REPORT UPDATE

Application No: EP/136/18/PL

LOCATION: Tudor Lodge
125A Sea Road
East Preston
BN16 1NX

PROPOSAL: Variation of condition 2 imposed under EP/59/17/PL relating to approved plans concerning updated site plan & ground floor plan.

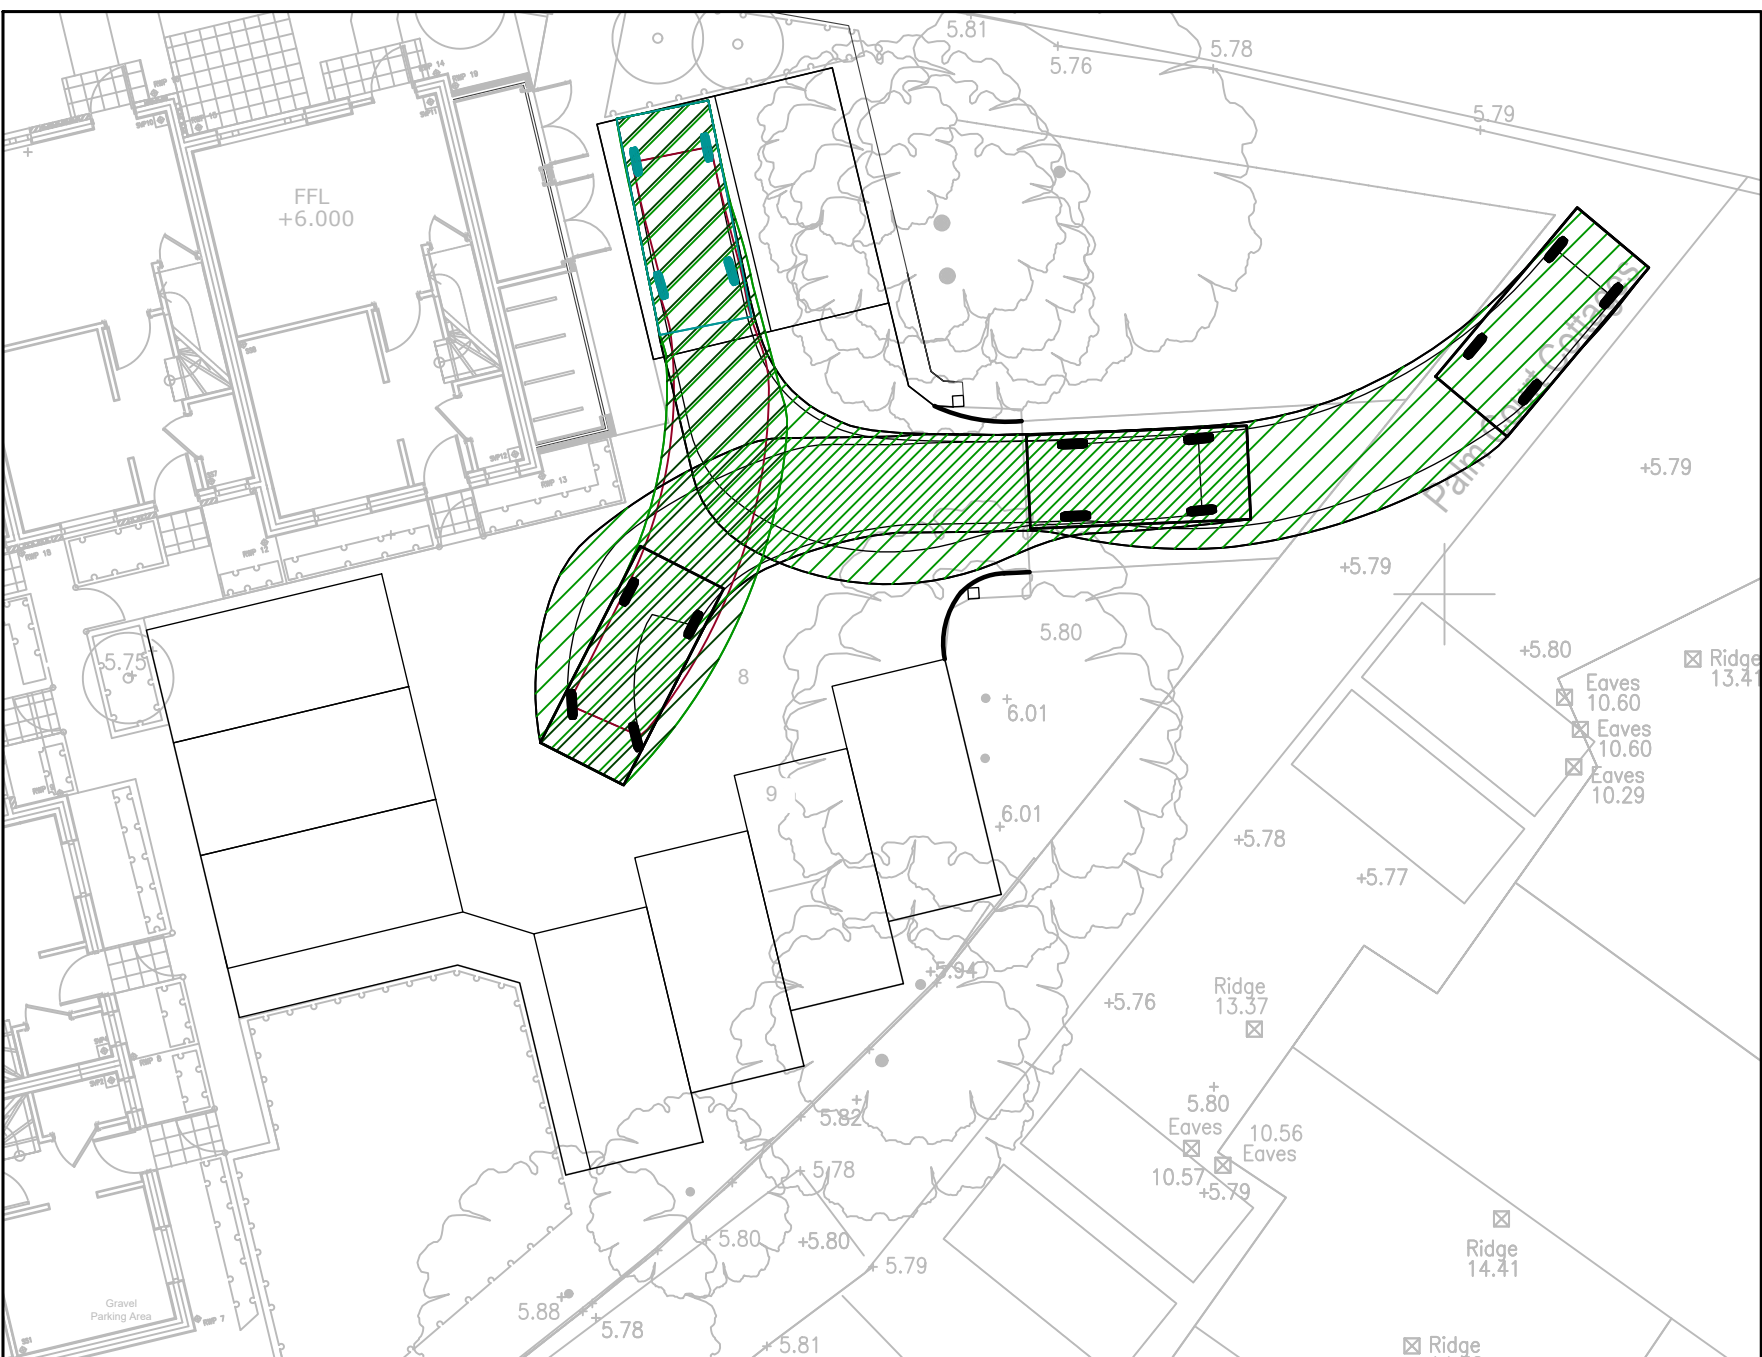
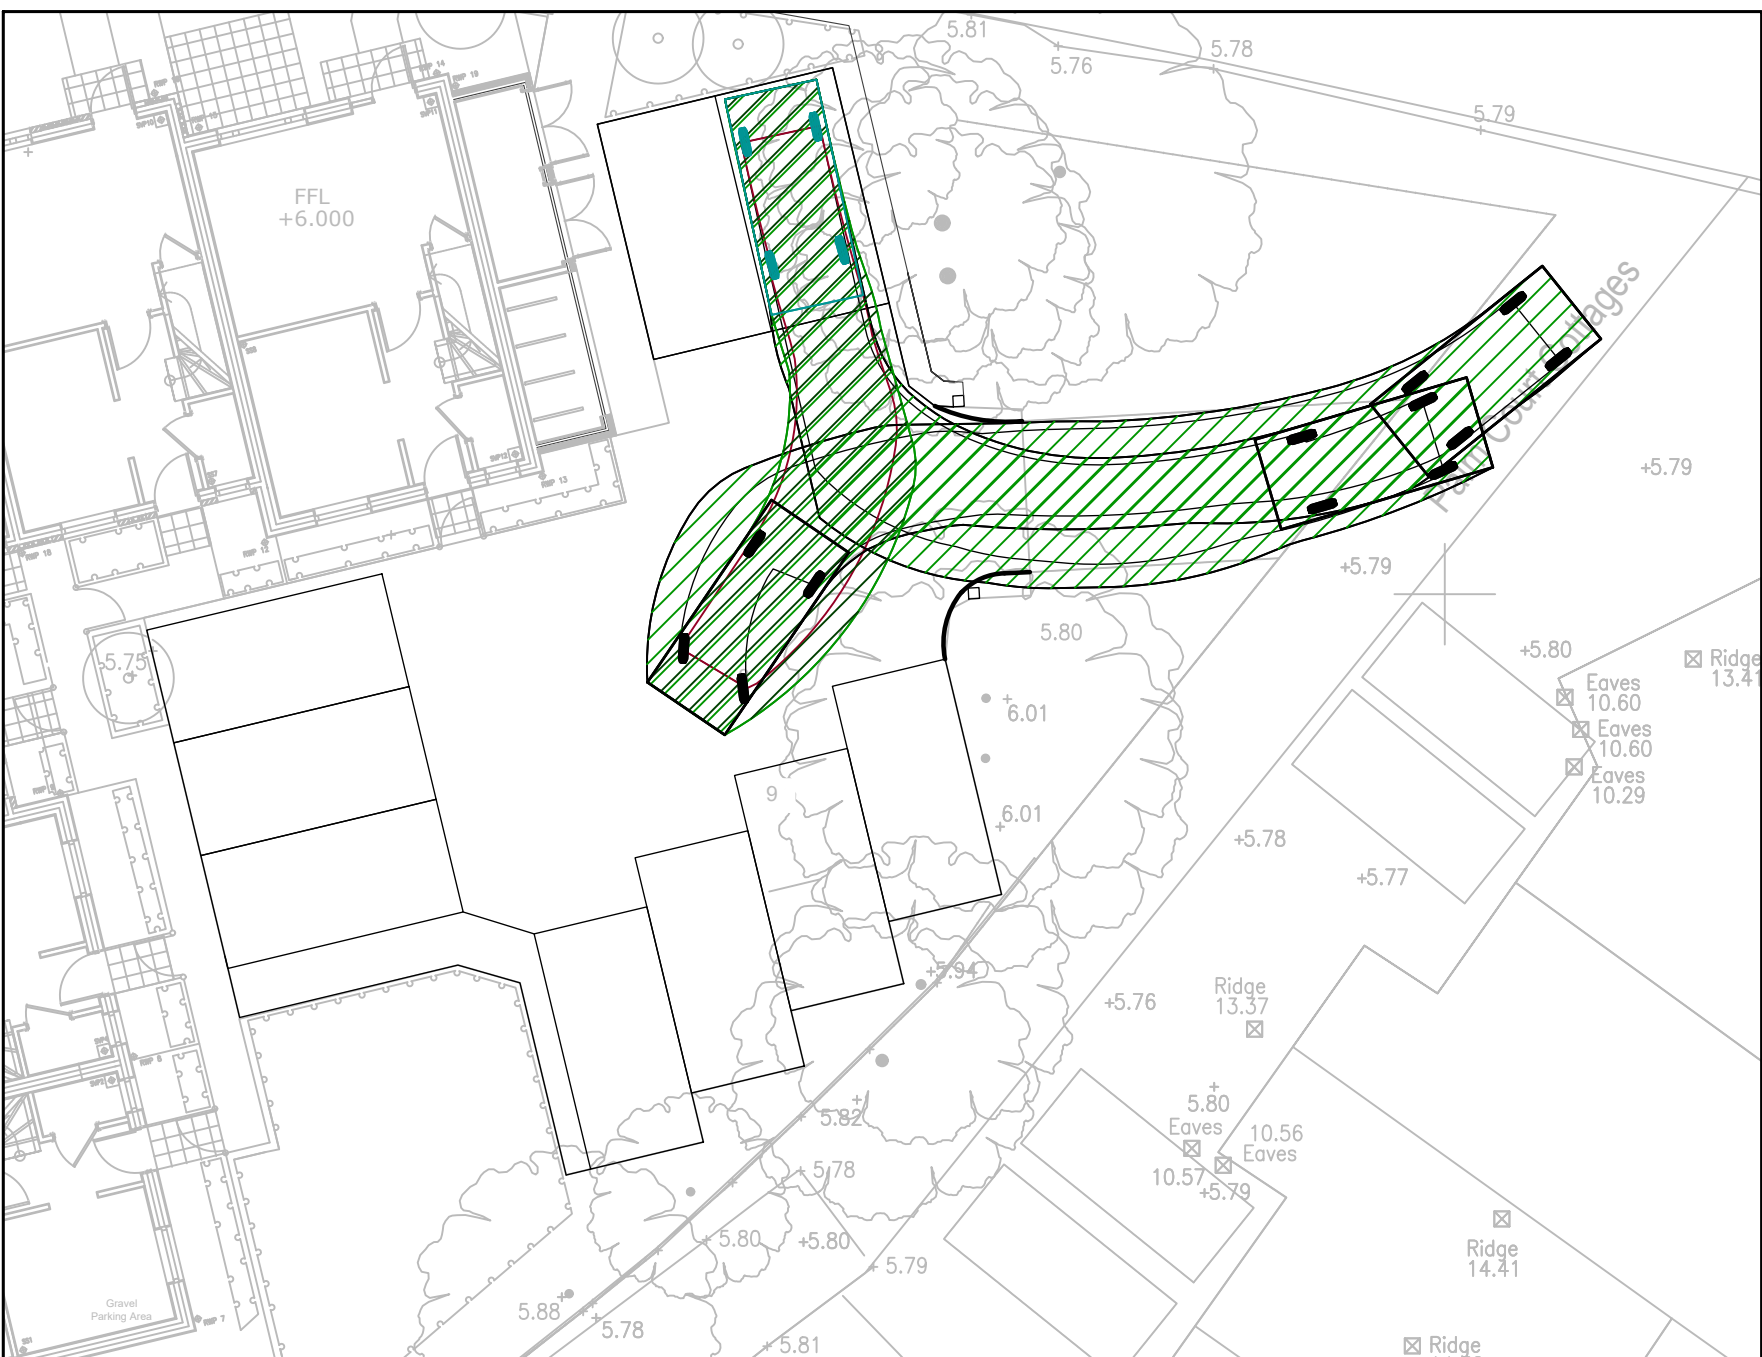
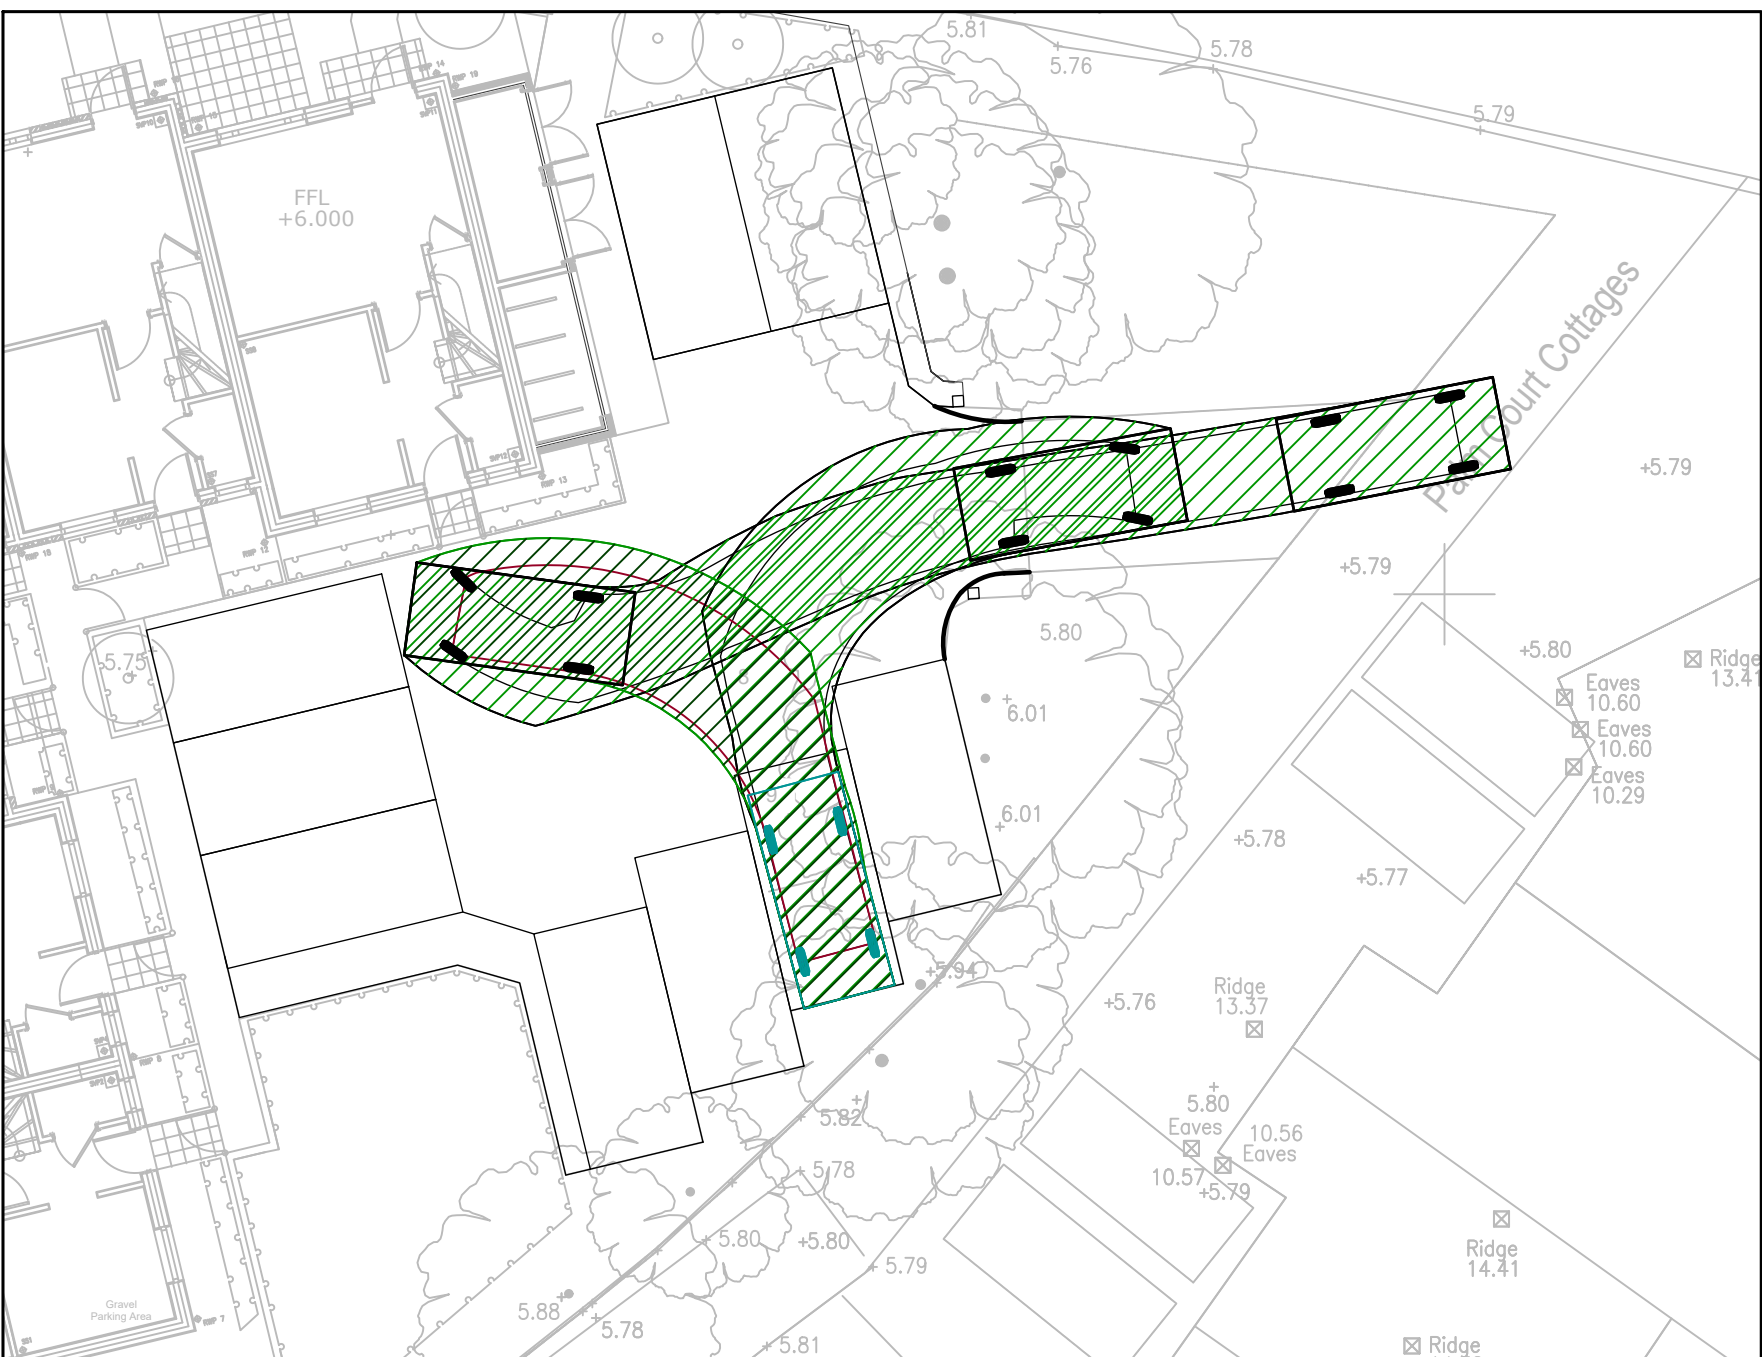
The agent has submitted additional plans which indicate swept paths for vehicles accessing the site and neighbour parking. The drawing has been fully tracked for all of the routes and spaces shown and is fully workable. The position of the entry point to the site remains unaltered. These plans have been submitted to address the concerns of third parties. For clarification purposes plan reference C-95-100 will be removed from condition no 1 and replaced with one that reflects access out onto South Strand. The plan is in the process of being prepared. Condition no 1 will be amended to reflect this possible access. However, if traffic was to access onto Palm Court Cottages this would be a private matter outside of planning control.

County Highways - No Objection. There are no changes to access or the amount of parking spaces. The parking area has been reconfigured. Tracking has been provided to demonstrate that the layout is workable. WSCC would raise no highway safety concerns to the proposed change.
